# CITY OF PORTLAND, MAINE

July 26<sup>th</sup>, 2011

**Project Name:** Harborview Townhomes  
New building comprising 7 residential units  
(19 space parking lot shared with existing 12 unit residential building)  
**Project ID:** 2011-214  
**Project Address:** 127 York Street (aka 121-129 York Street)  
CBL: 44 - A-004/005

## MEMORANDUM

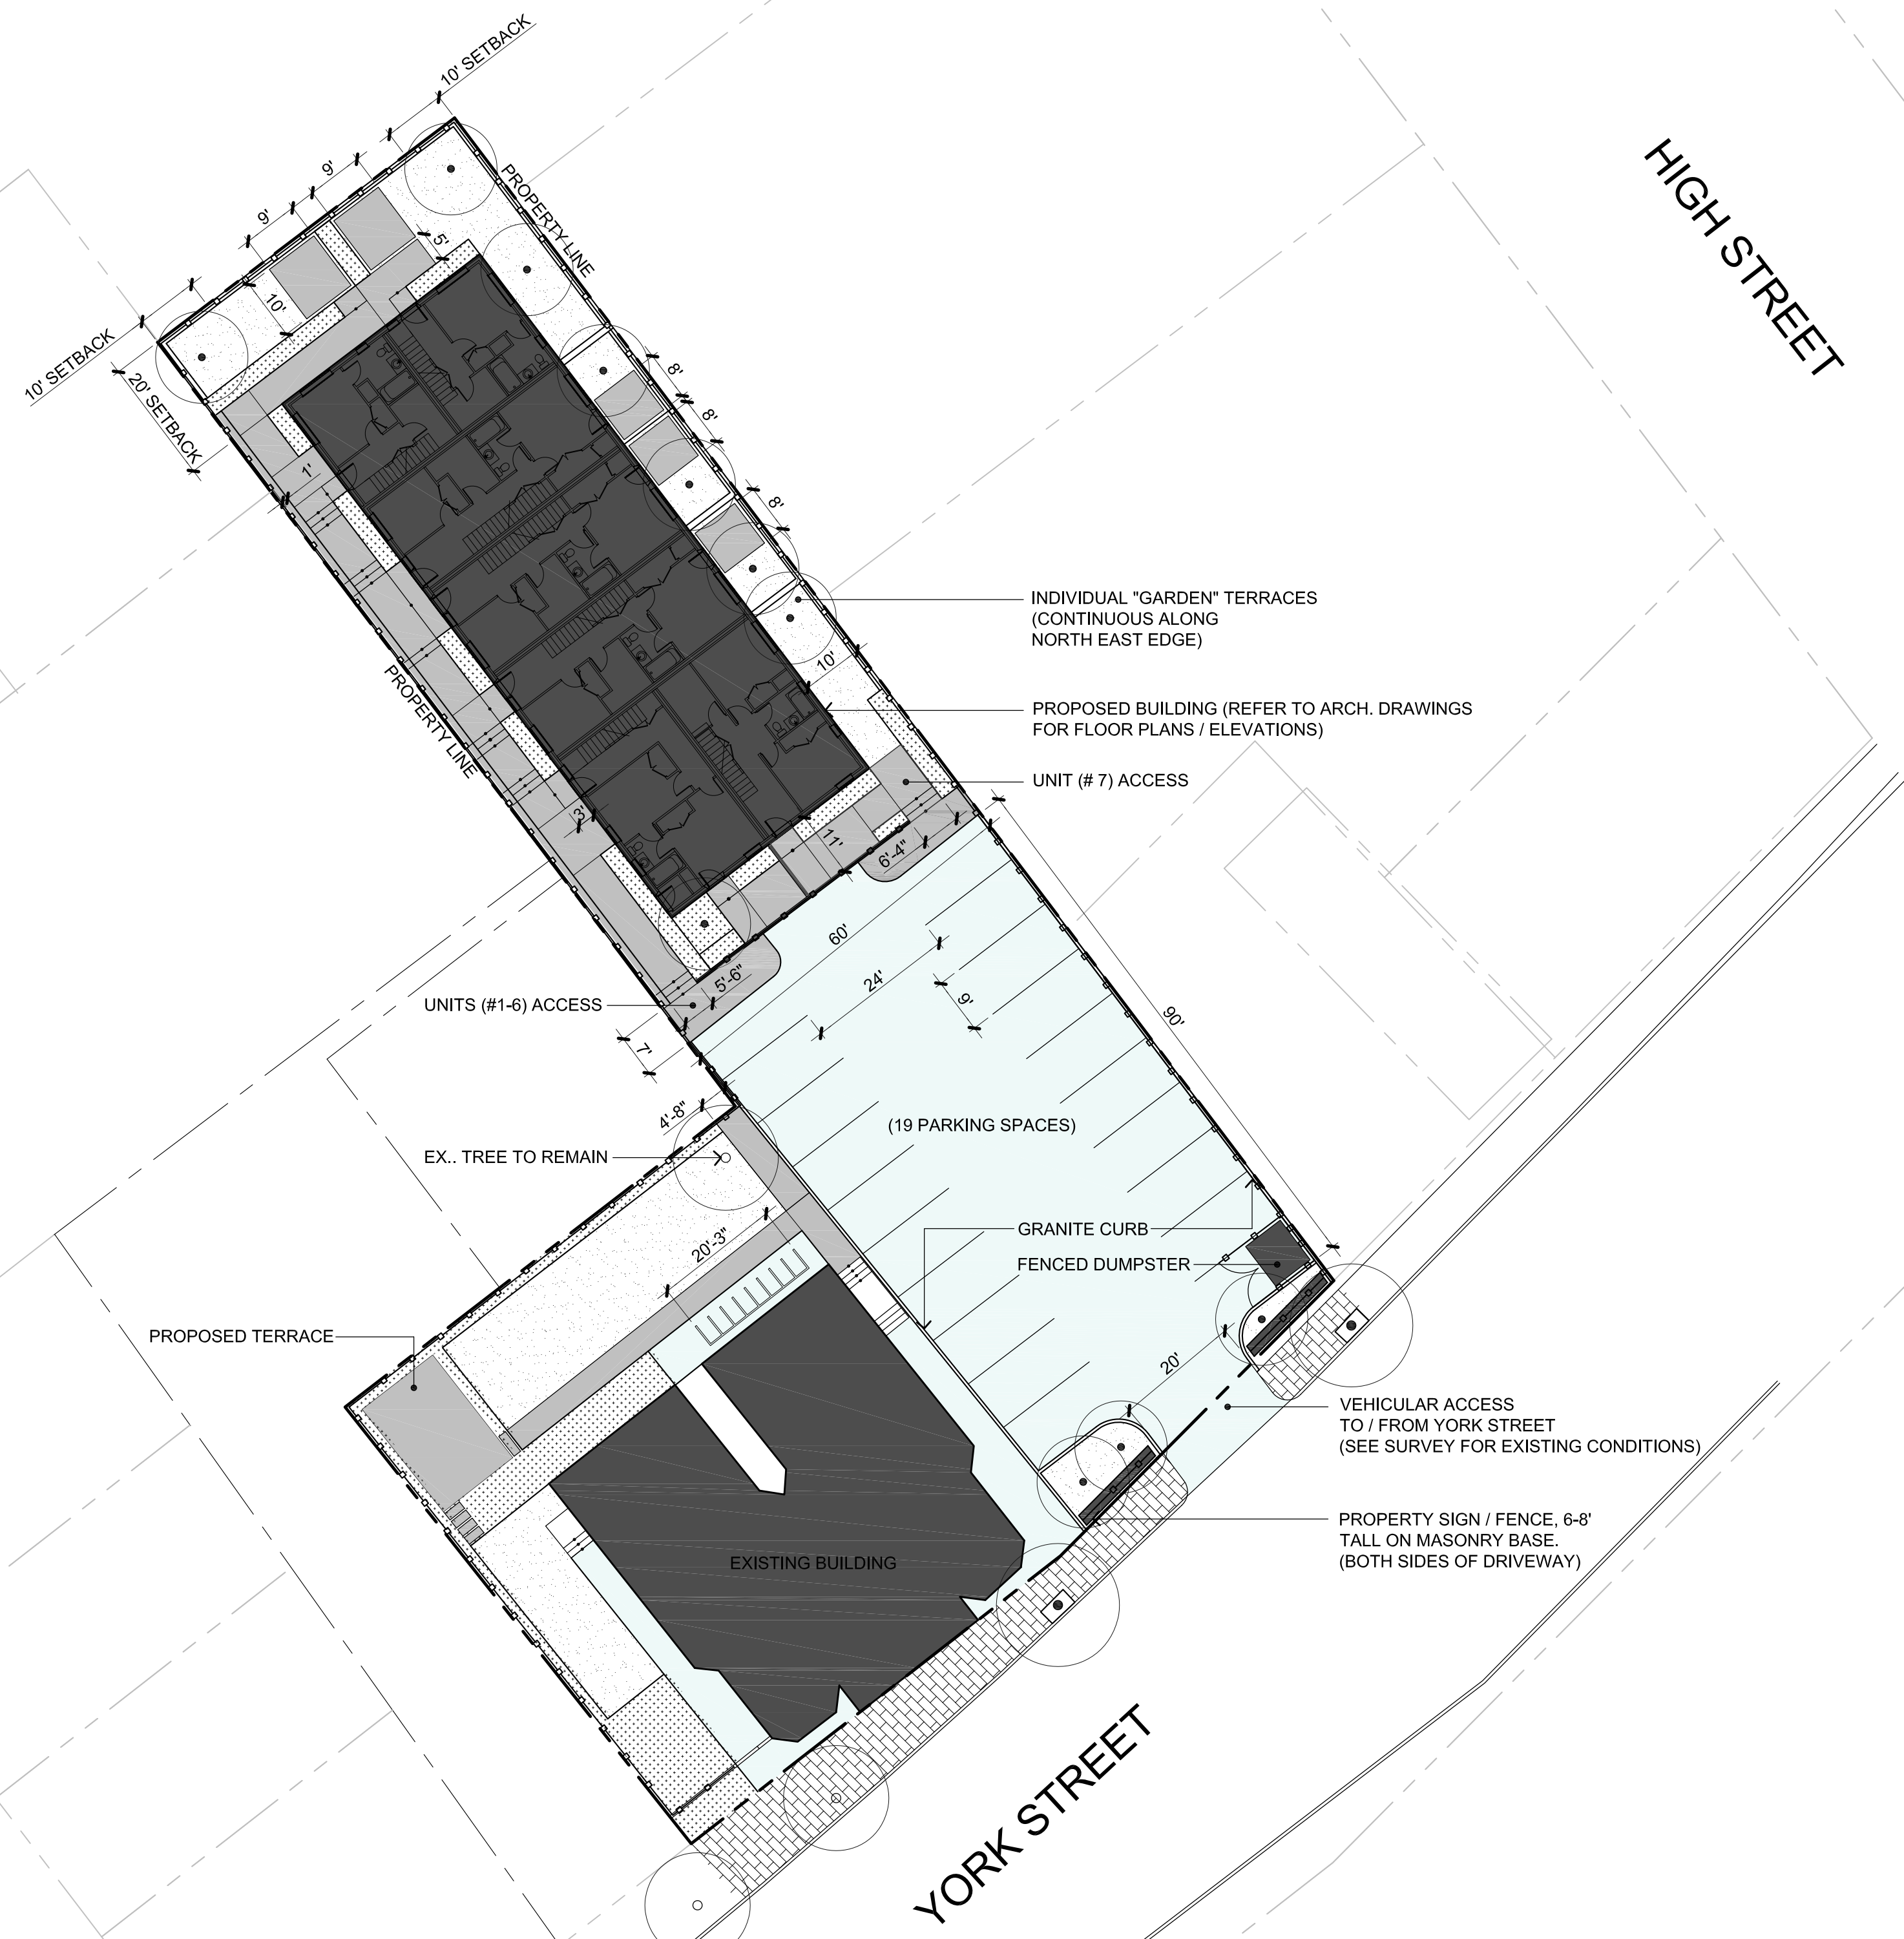
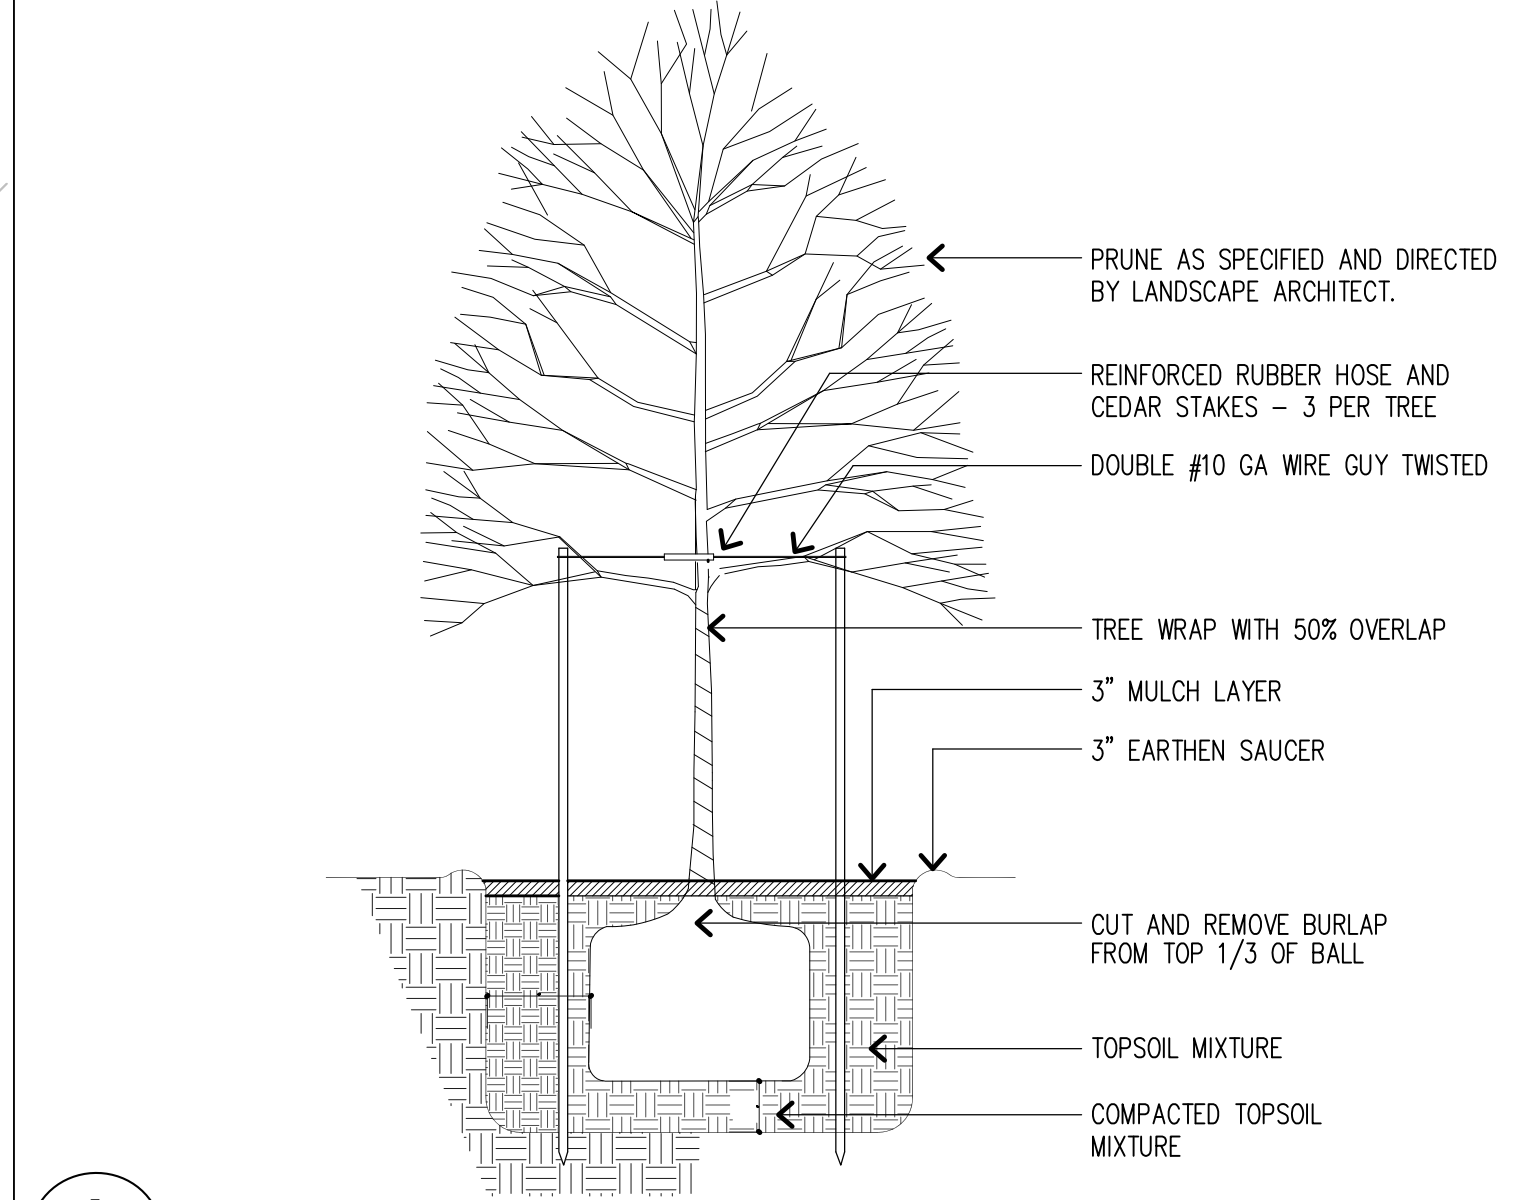
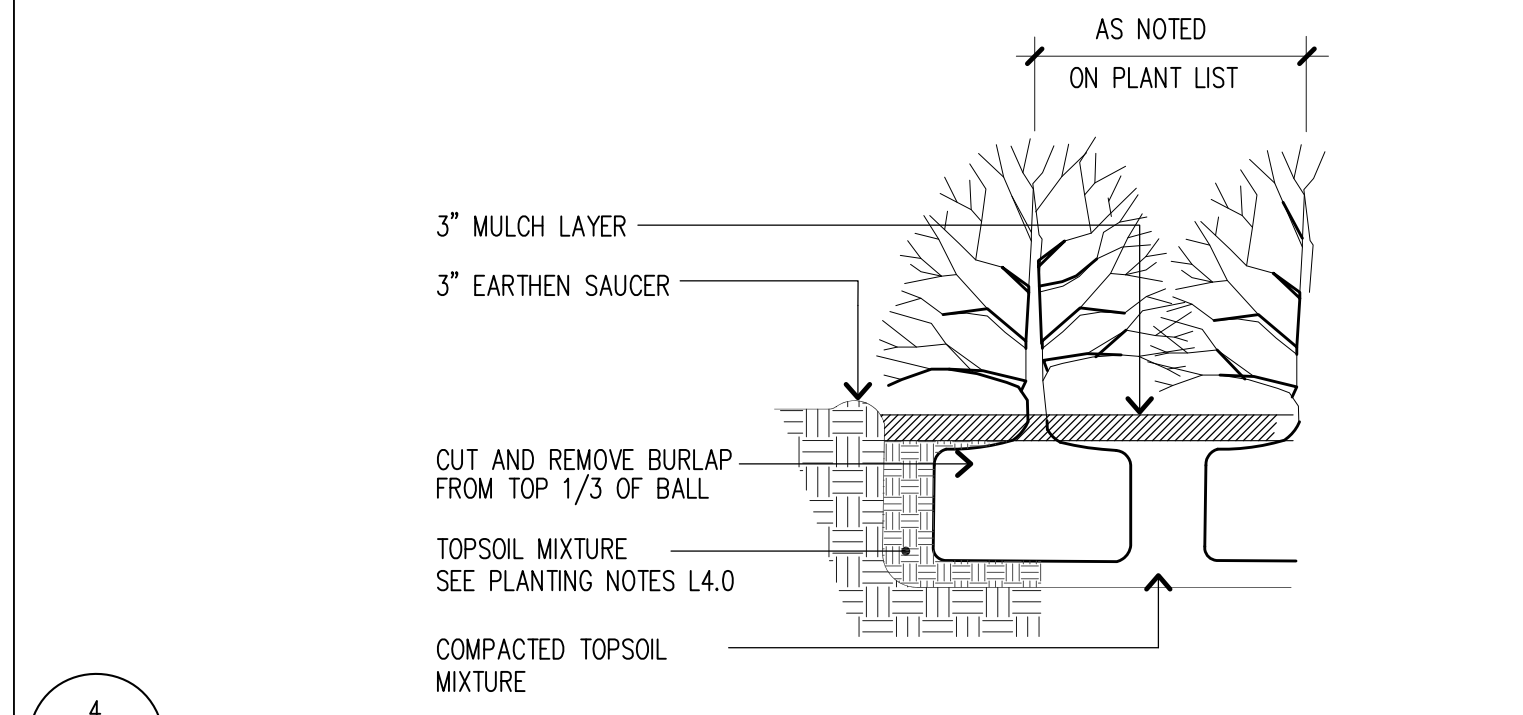
**a) Landscape plan** - the landscape plan, shown on sheets L-1.0 L-2.0 and L-3.0 should include a plant key or schedule that lists botanical and common plant name and location on the plan. While Sheet L-1.0 does show a Symbols Legend with plant names it would be good to have a more detailed plant key or schedule, Sheet L 1.0 shows (8) Amelanchier SP (1.75" CAL.) and (8) 'Armstrong' Red Maple (2.5" CAL.) with the later showing a larger graphic symbol finding the actual trees on the sheet could be clearer, I counted 17 circles or trees on design sheet and 16 trees on the Symbols Legend.

**b) Tree Saves** - the landscape plan Sheet L 3.0 shows details on tree protection, Sheet L 1.0 shows three trees, two along the sidewalk and one near the back corner of the existing building to be saved. The project should also take measures to protect trees on adjacent properties during site work, this would include root pruning exposed roots found during excavation and pruning any damaged limbs during construction. These items can be reviewed during the project 'Pre-Construction' meeting.

**c) Street-trees & Parking Lot trees** - The landscape plan includes two existing street trees along York Street and proposes to plant two additional trees ('Armstrong' Red Maples near the entrance driveway. The new street-trees are planted with tree grates, (Neenah R-8810 recommended) the location of tree on the right or High Street side of driveway may need to be adjusted to maintain sidewalk width for snow plowing and access. A second option would be to include this tree into the planting space with the other two trees. Parking Lot trees - the parking lot area contains 19 parking space creating a need for 10 trees to meet the Parking Lot Landscape Standard. The plan proposes six trees near the York Street entrance, three near the proposed building front and one near the existing building - which is "close". Ideally, one additional tree perhaps planted on the adjacent private property mid way up the right side of the parking lot would be a creative solution. It would help the parking lot standard and additional screening for the neighboring property.

**d) Landscape treatment** - In addition to the 'tree saves' and 'street & parking lot' trees the project mentions "planted landscape buffer" near the York Street entrance, 'individual garden terraces', 'raised planters along entry corridor', 'front patio garden' and two 'lawn' areas near the existing building are shown on Sheet L 2.0. Landscape treatment details, shrub and herbaceous landscape plant information and placement is needed on the plan. The landscape legend as shown does not mention any shrub planting.

- 1) Landscape Key / Plant List needed for trees, shrubs & herbaceous planting.
- 2) Tree Save - include tree protection measures to include 'off-site' trees.
- 3) Landscape Treatment, trees / shrub proposed for the areas shown as 'individual garden terraces', 'raised planters along entry corridor', 'front patio garden' should be included or shown in detail on the landscape plan.
- 4) to meet the standards of trees per unit and parking lot landscape three additional trees are needed.
